Date: 6 June 2019

APPLICATION CONSULTATION RESPONSE

Application Number:	3/2018/0786
Location:	Dog and Partridge, Hesketh Lane, Chipping, PR3 2TH
Proposal:	Conversion of an existing restaurant (A3) to create twelve apartments (C3) and the siting of four holiday lets.

# PROPOSED BLOCK PLAN

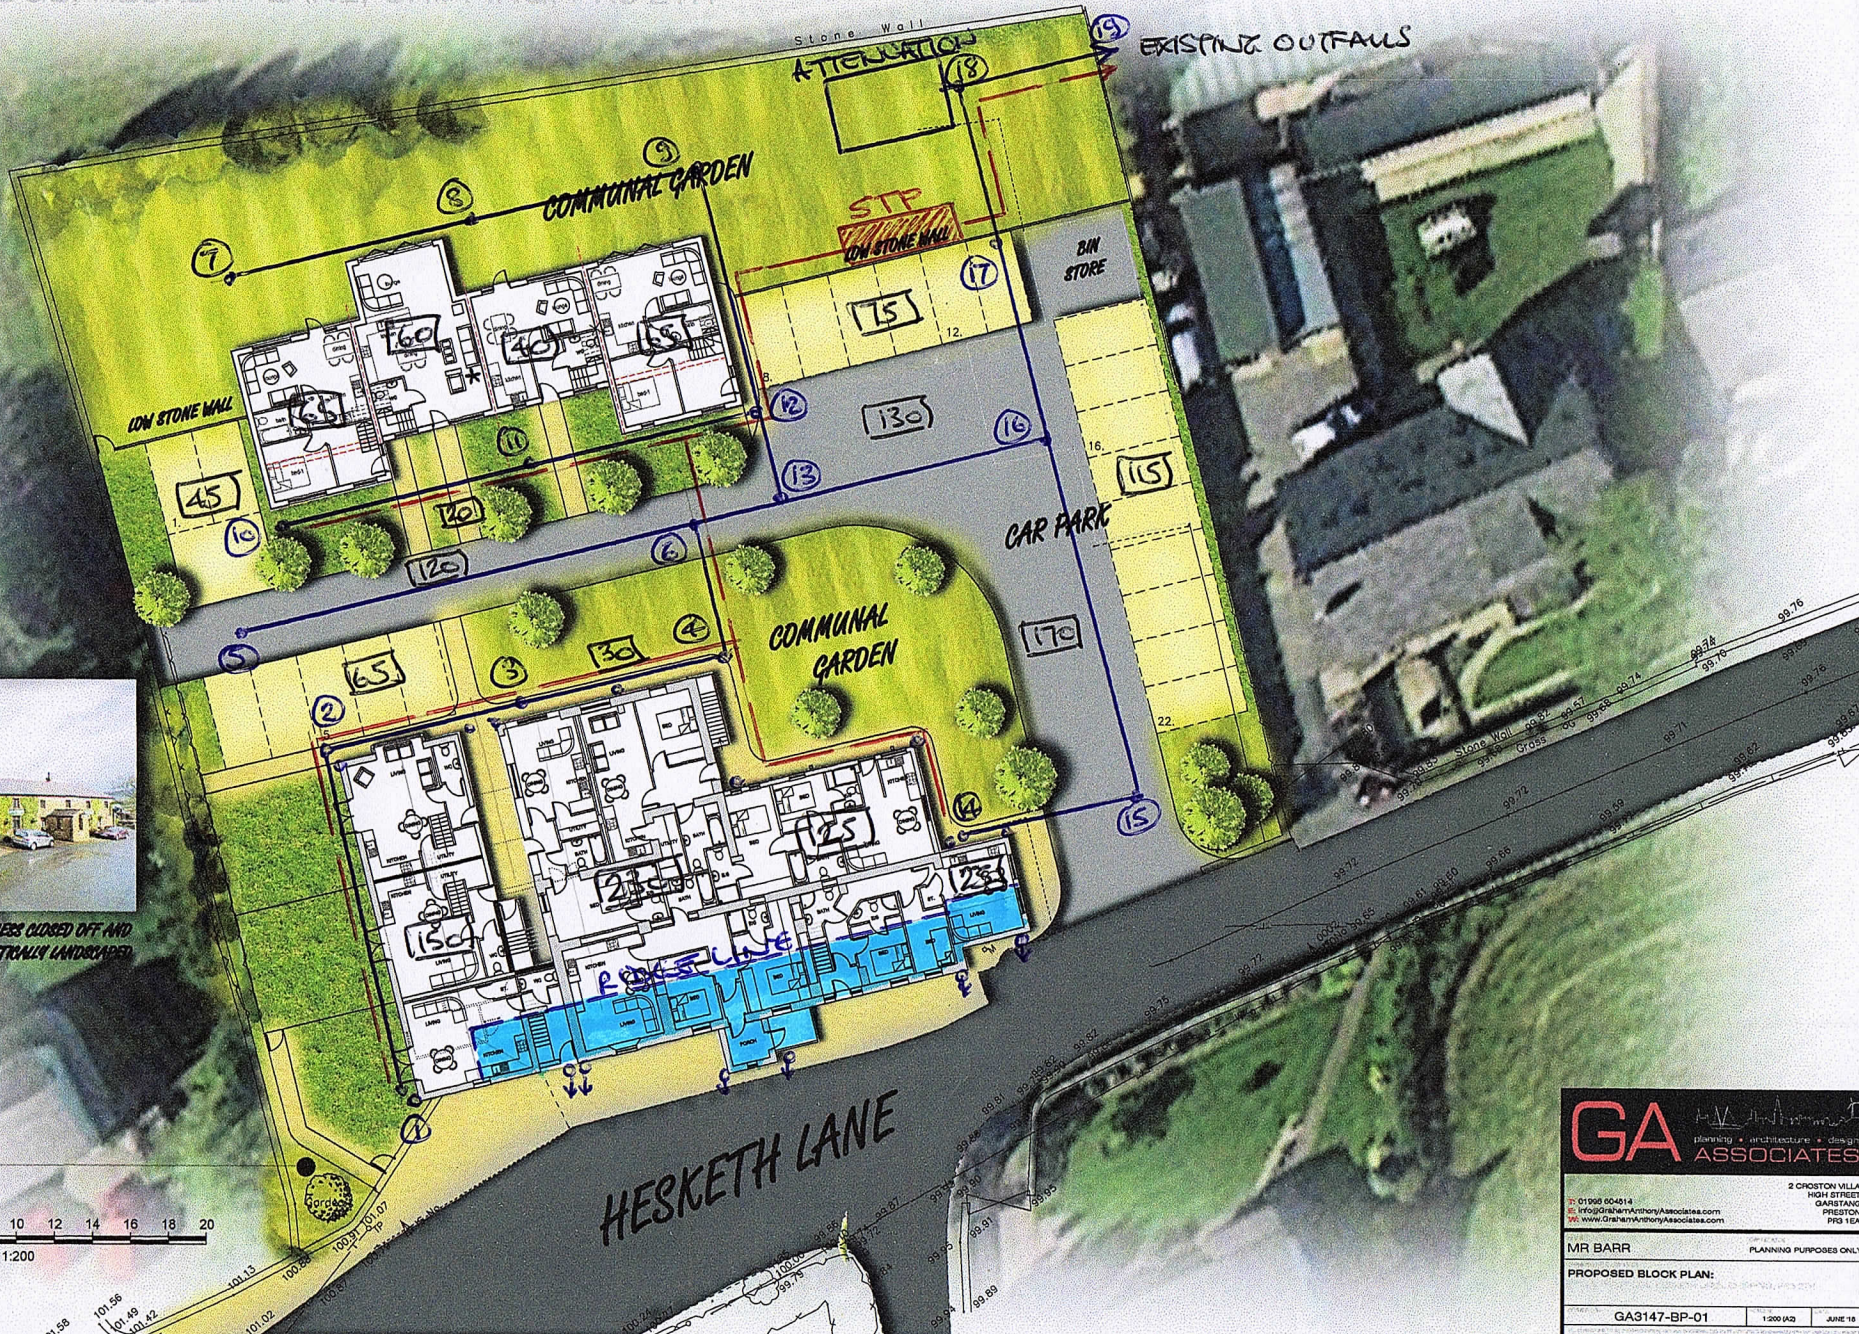
The LLFA understands that the surface water drainage scheme outlined on drawing no. GA3147-BP-01 is only a preliminary issue and may be subject to change following further detailed design and investigation. As the submitted plans are still subject to change, the plans cannot be considered for approval at this time. The applicant will instead need to provide the final details once the detailed design and investigation work has been completed. The final plans will need to be submitted to and approved by the LPA prior to the commencement of any development, and must comply with the requirements of the National Planning Policy Framework and the non-statutory technical standards for sustainable drainage systems; March 2015. The LLFA is satisfied that the final drainage details can be secured through the inclusion of the above recommended planning condition.

No development shall commence until final details of the design, based on sustainable drainage principles, and implementation of an appropriate surface water sustainable drainage scheme have been submitted to and approved in writing by the local planning authority. Those details shall include:

- a) A final surface water drainage layout plan; appropriately labelled to include all pipe/structure references, dimensions, design levels, finished floor levels and external ground levels (in AOD);

- b) A full set of flow calculations for the surface water drainage network. The calculations must show the full network design criteria, pipeline schedules and simulation outputs for the 1 in 1 year, 1 in 30 year and 1 in 100 year return period, plus an appropriate allowance for climate change and urban creep. The calculations must also demonstrate that the post development surface water run-off rate shall not exceed 5l/s;

- c) A final plan showing all on-site surface water catchment areas, i.e. areas that will contribute to the proposed surface water drainage network;
- d) A final plan showing all overland flow routes and flood water exceedance routes, both on and off site;
